# Access Review

Samuel Gilbert Public School  
Ridgecrop Drive Castle Hill  
Report Issue 1 (Revised) Final  
12/11/18

This review of the design documents for SSDA submission addresses the requirements for access by staff, students and visitors with a disability or who are older, to the proposed upgrades to Samuel Gilbert Public School, Ridgescrop Drive, Castle Hill. The numbers of students and staff are as follows:

PROJECT NUMBER 7068SG01	DIRECTOR JW	CHECKED AS
DRAWING NUMBER SD-P-2003	REVISION P14

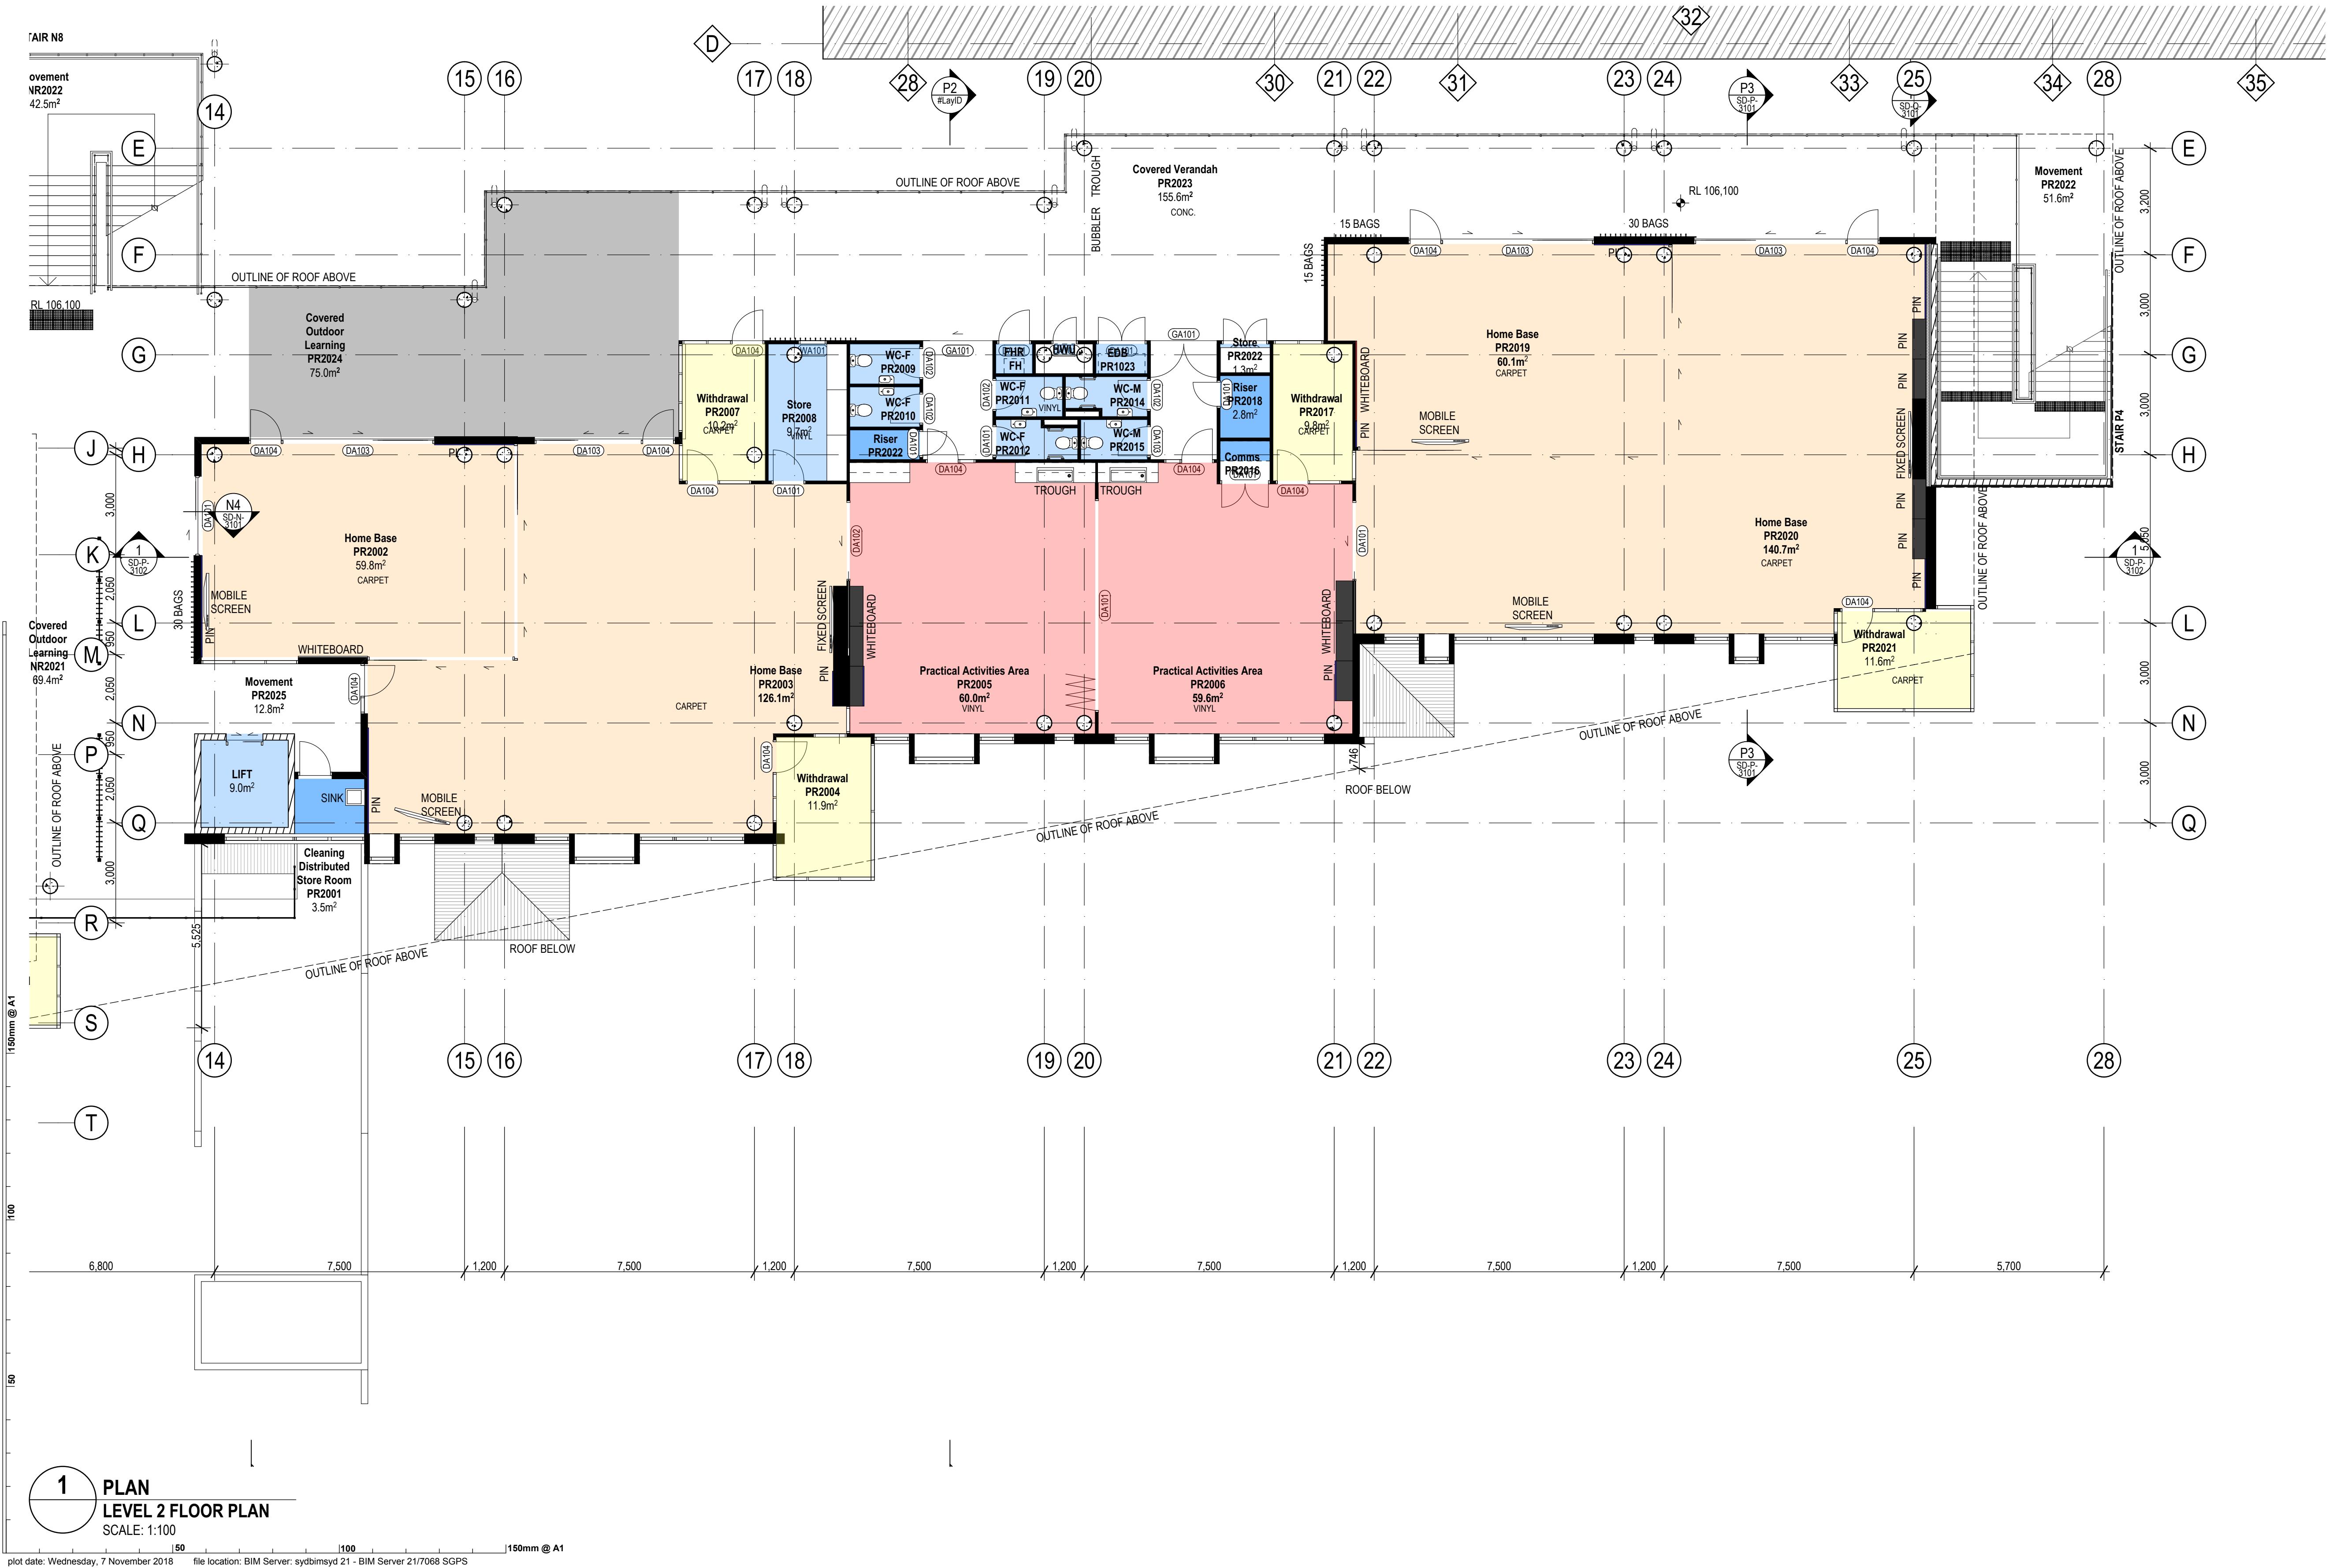
A tiered seating area is proposed in the library. Wheelchair seating spaces are proposed to be provided on the ground floor and Level 1 (accessed via lift). The wheelchair seating spaces are indicated to have dimensions and manoeuvring space in accordance with AS1428.1 clause 18.
